CITY OF PORTLAND, MAINE

3 Bond Street

March 29, 1988

This is in further reference to your application for a change of use from three to five apartment units for the building at 3 Bond Street in the R-6 Residence Zone. There has been a recent new amendment to the City Zoning Ordinance which went into effect on December 2, 1987. A copy of this amendment is enclosed.

3rd FLOOR

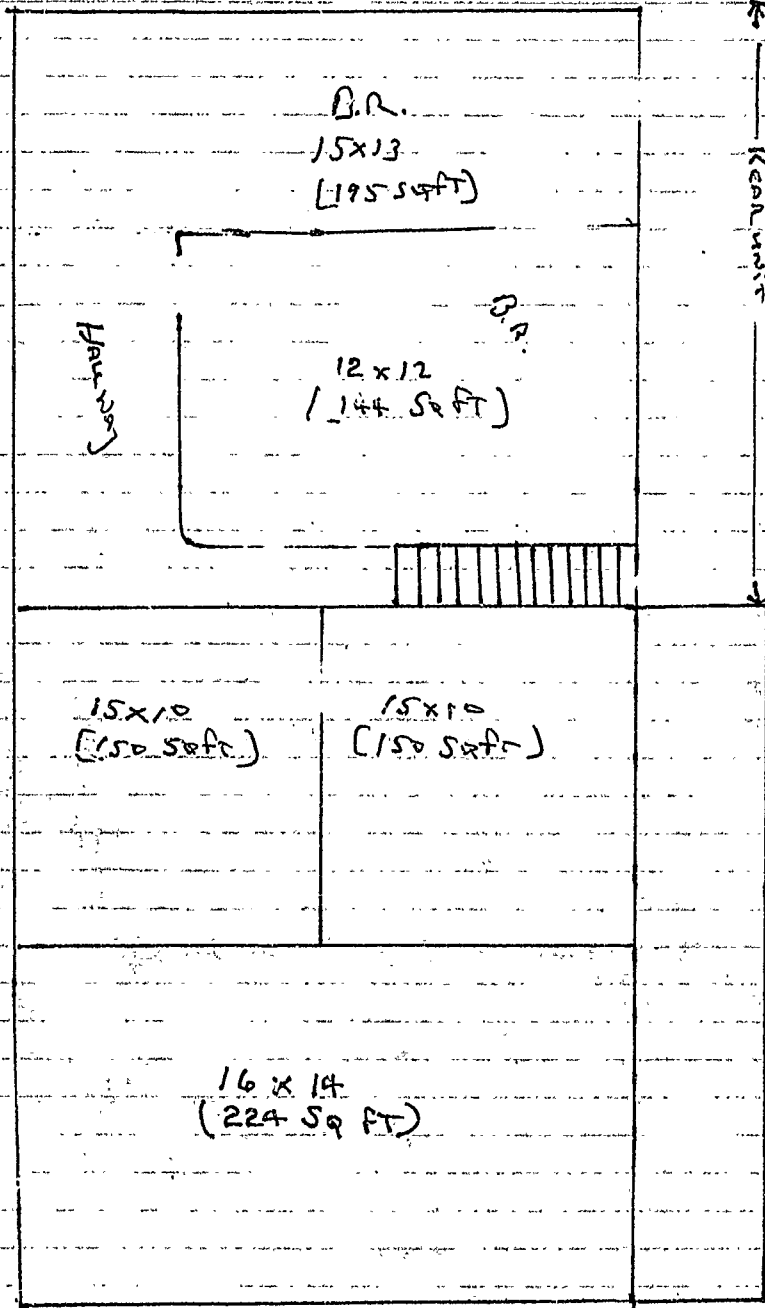
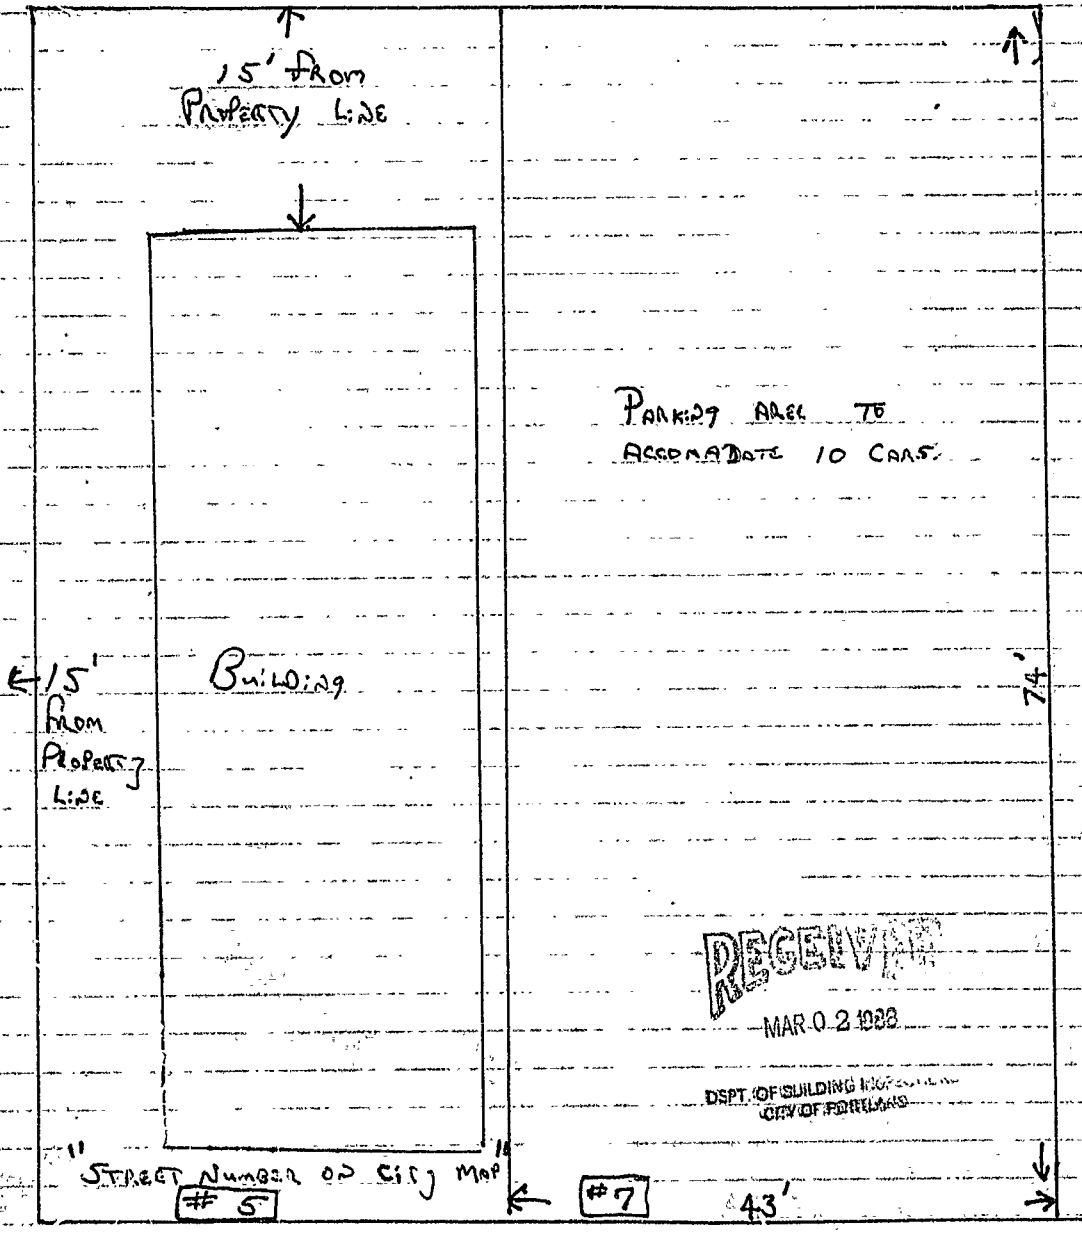
Please review your plans and advise us as to whether or not these proposed new units (particularly those on the third floor) meet the minimum apartment sizes as established by the City Council's amendment to the R-6 Residence Zone.

3rd FLOOR 5 EXISTING BEDROOMS

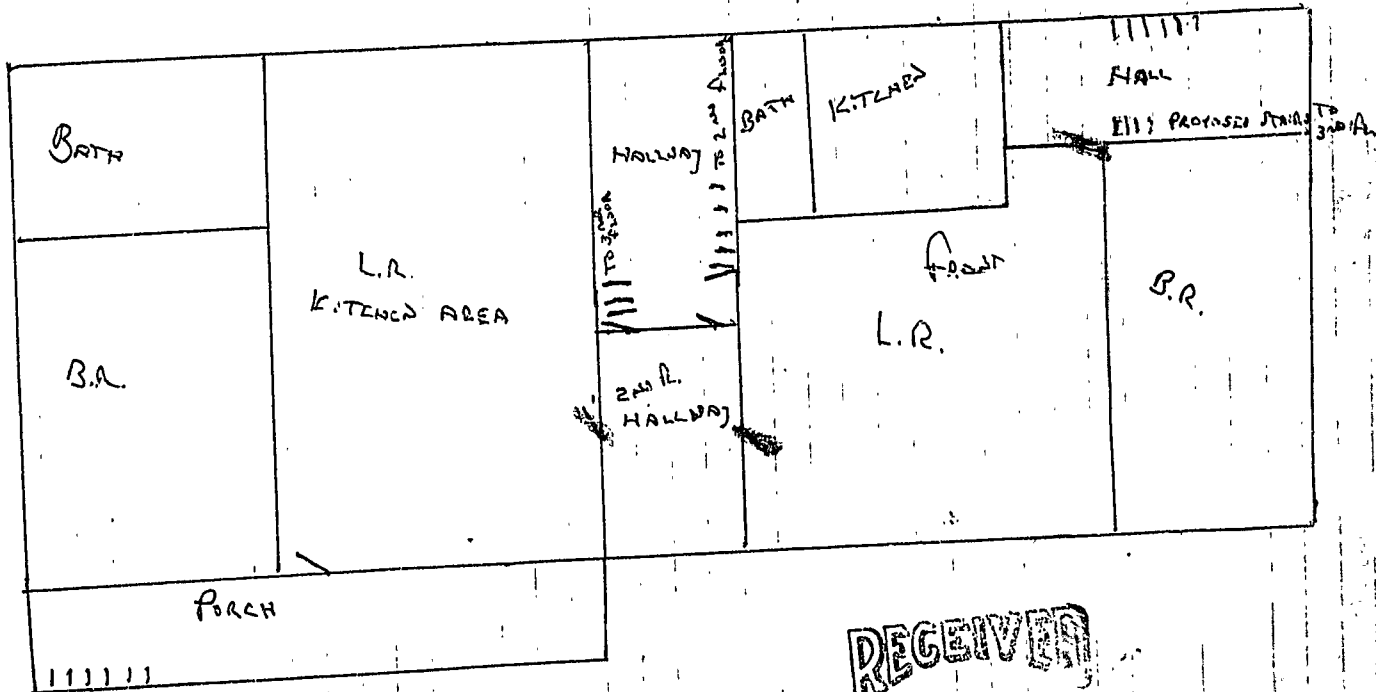
In short, it says that the main apartment unit must be not less than 1,000 square feet of floor area, and that additional apartment units must be not less than 600 square feet of floor area each.
